Our Reference: SYD20/00773/03
Departments Reference: SSD-10479

EXHIBITION OF EIS - 106-228 ALDINGTON ROAD - KEMPS CREEK

The documentation, including *AsonGroup Transport Assessment Report* (TAR), in support of the proposal has been reviewed and comments and recommendations are provided in **Attachment A**.

Title
**VEHICLE
TURNPATH PLAN
SHEET 1**

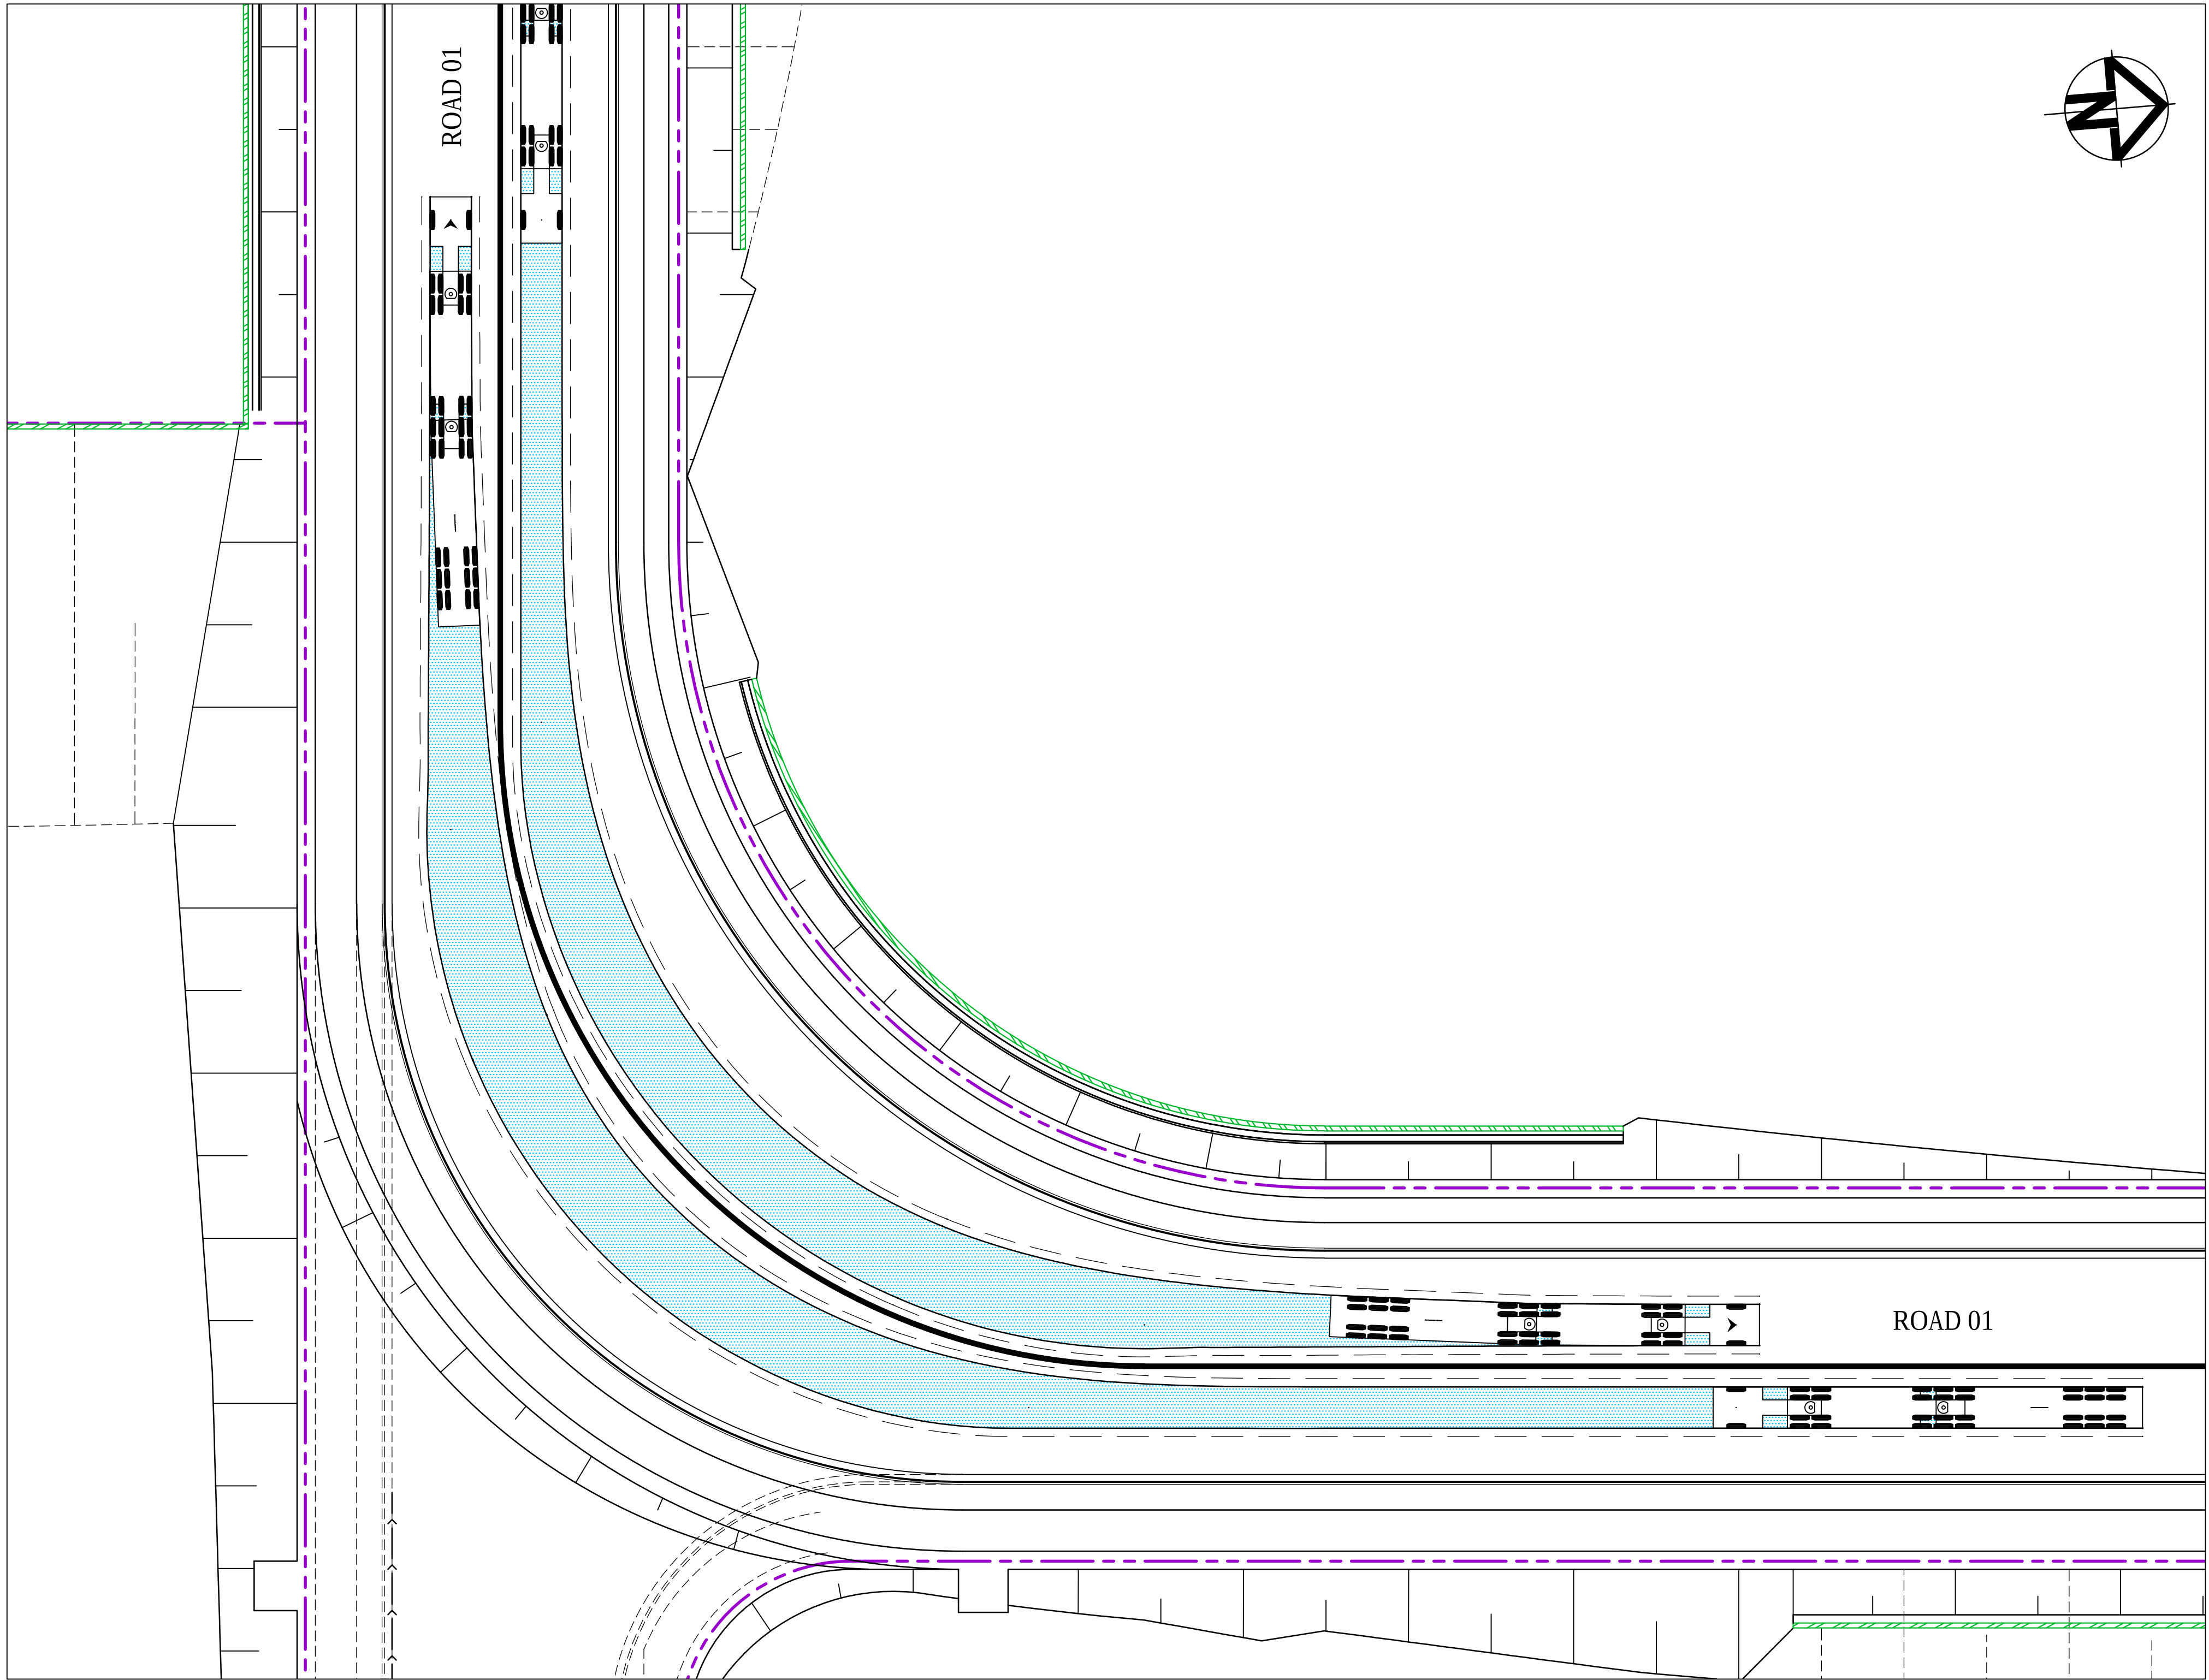
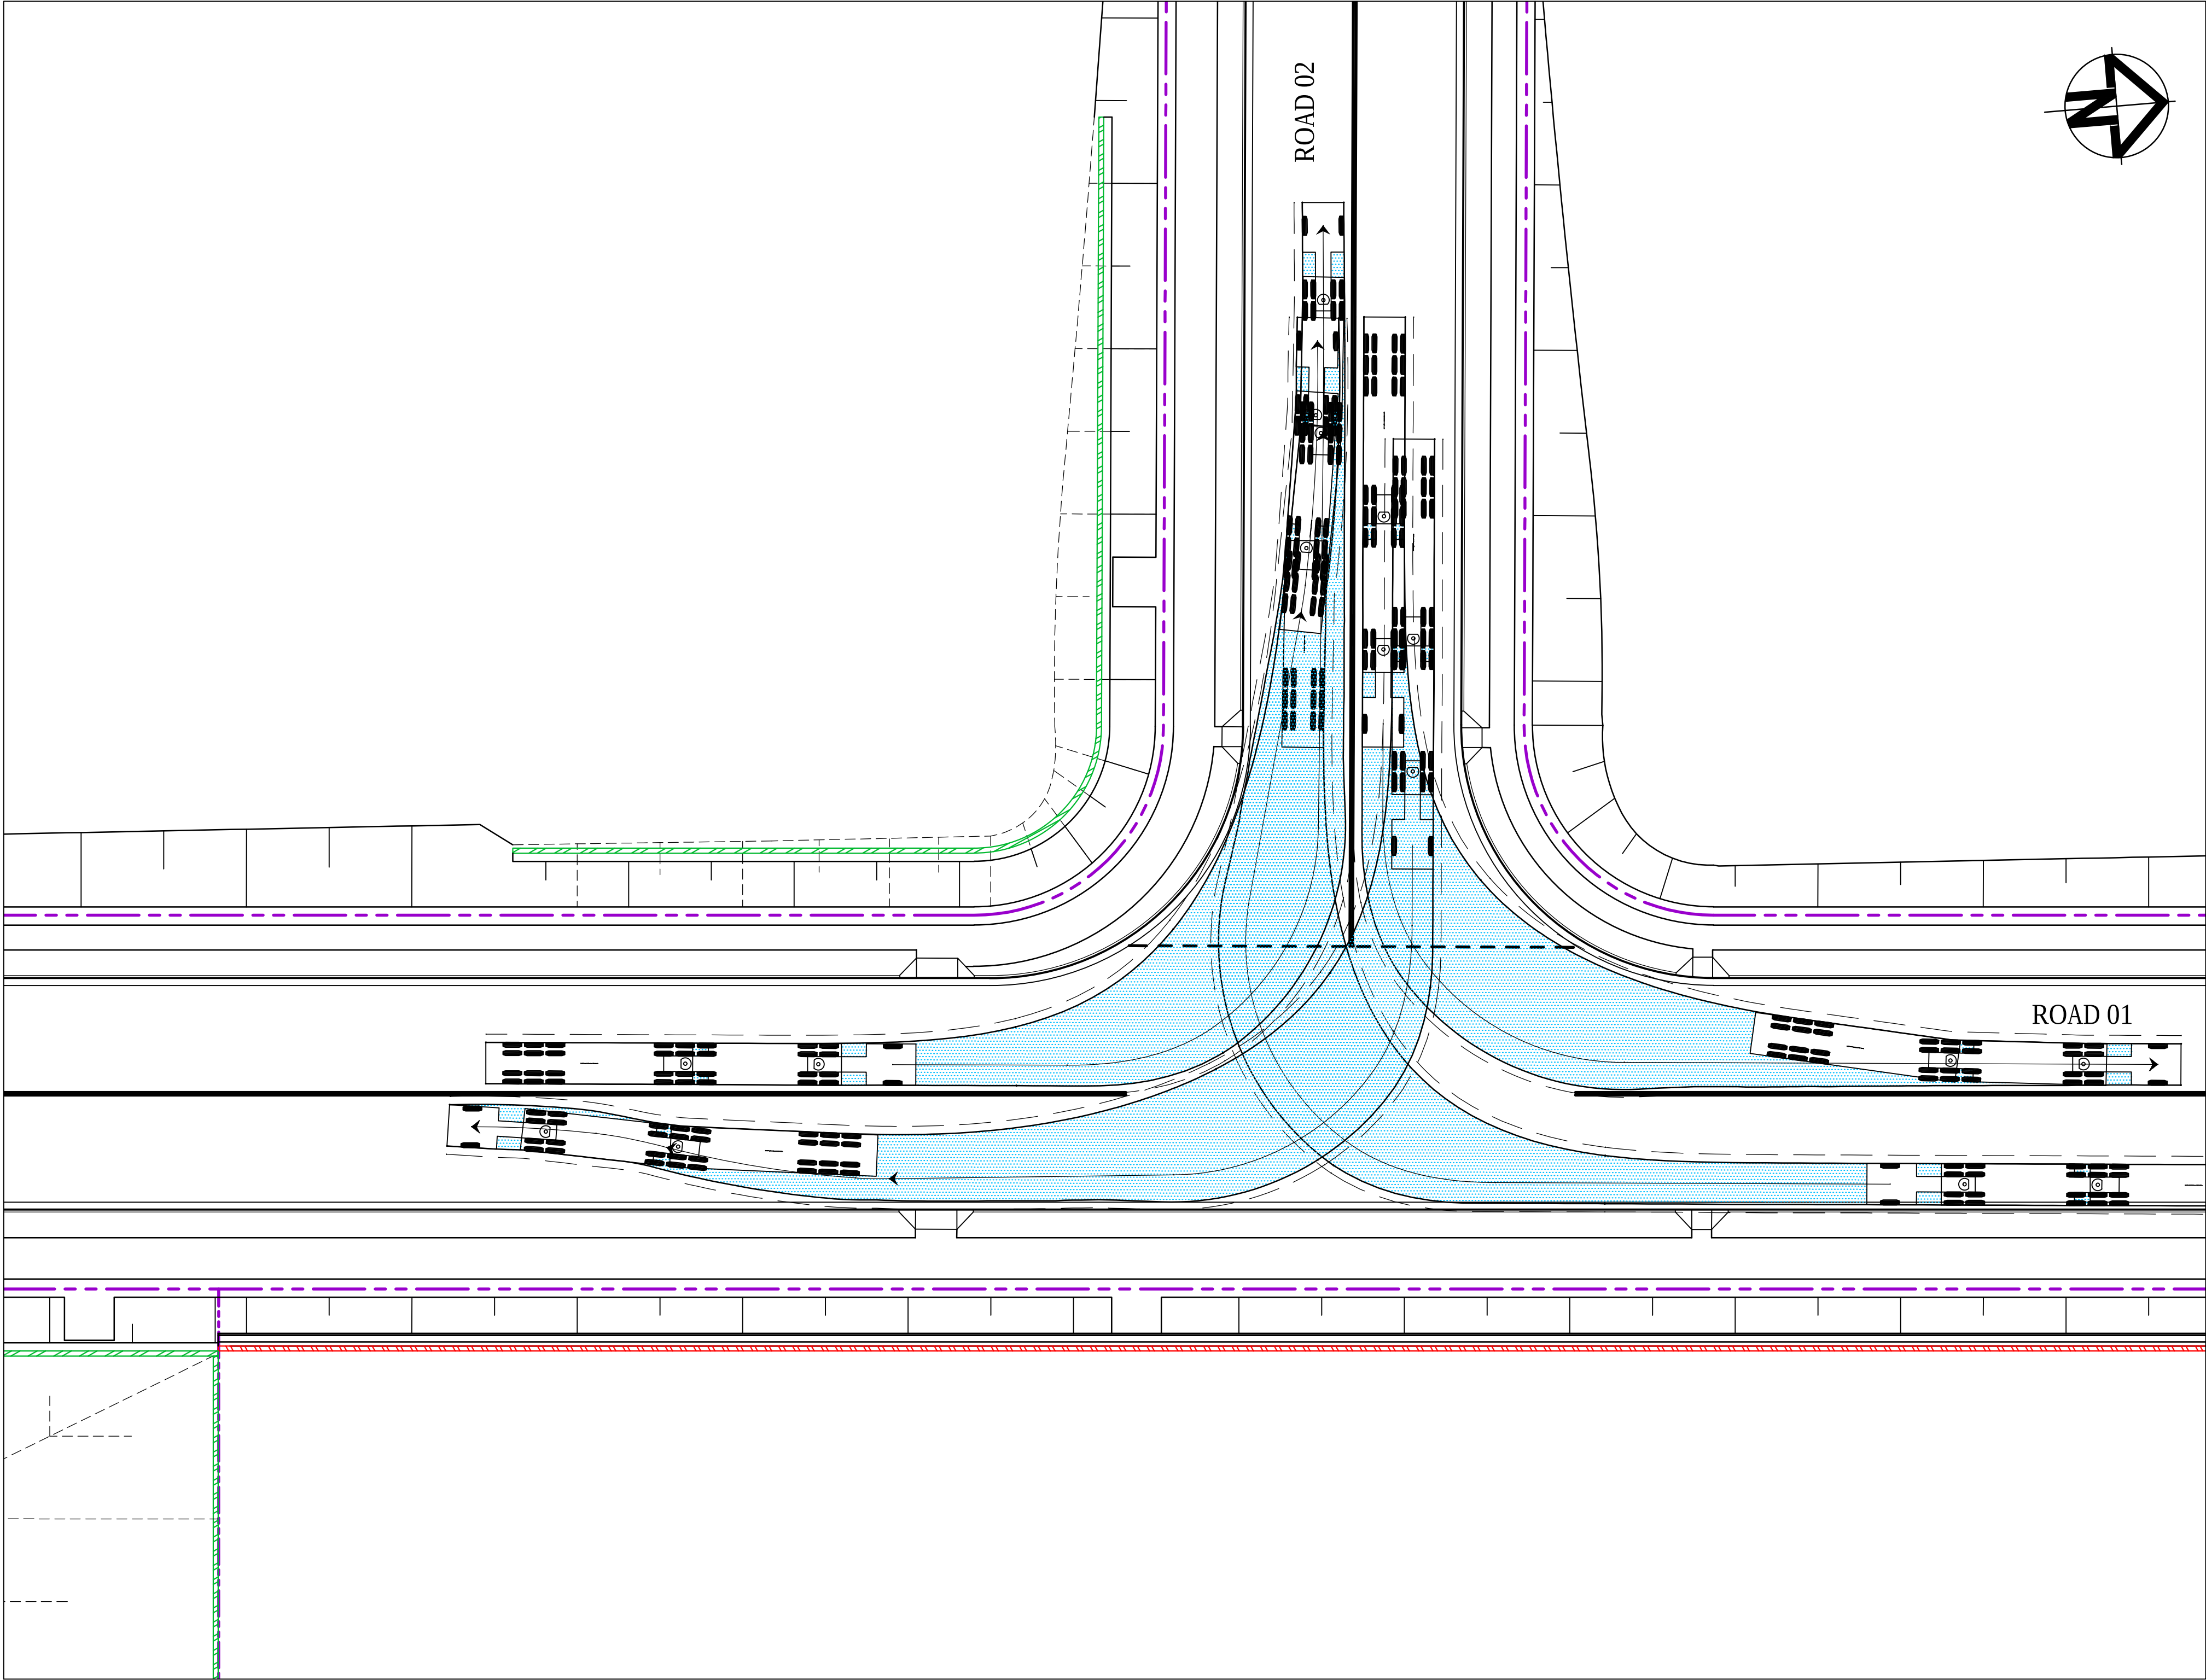
- d. Appendix B - the SIDRA results for the signalised intersection on Mamre Road/Abbotts Road show 80 seconds as the cycle time. The cycle times of all intersections should be modelled as a worst case scenario, this is achieved by using the maximum cycle time for the intersection. In this regard the model should be updated to use the correct maximum cycle time of 140 seconds.
- e. Appendix C - The swept paths provided are of an articulated vehicle (19m). Swept paths will be required to be provided to accommodate the largest type of heavy vehicle which could reasonably be expected to service the site. The WSEA SEPP outlines the required vehicle lengths to be accommodated for.

In this regard, the design vehicle for the access to the site should be assessed with a 26m B-Double and a 30m PBS 2B vehicle. In addition, all swept paths are to be provided including the roundabouts.

TfNSW requests the abovementioned information to be addressed/provided for further assessment prior to the determination of the application. TfNSW will further review and provide response upon receipt of the additional information.
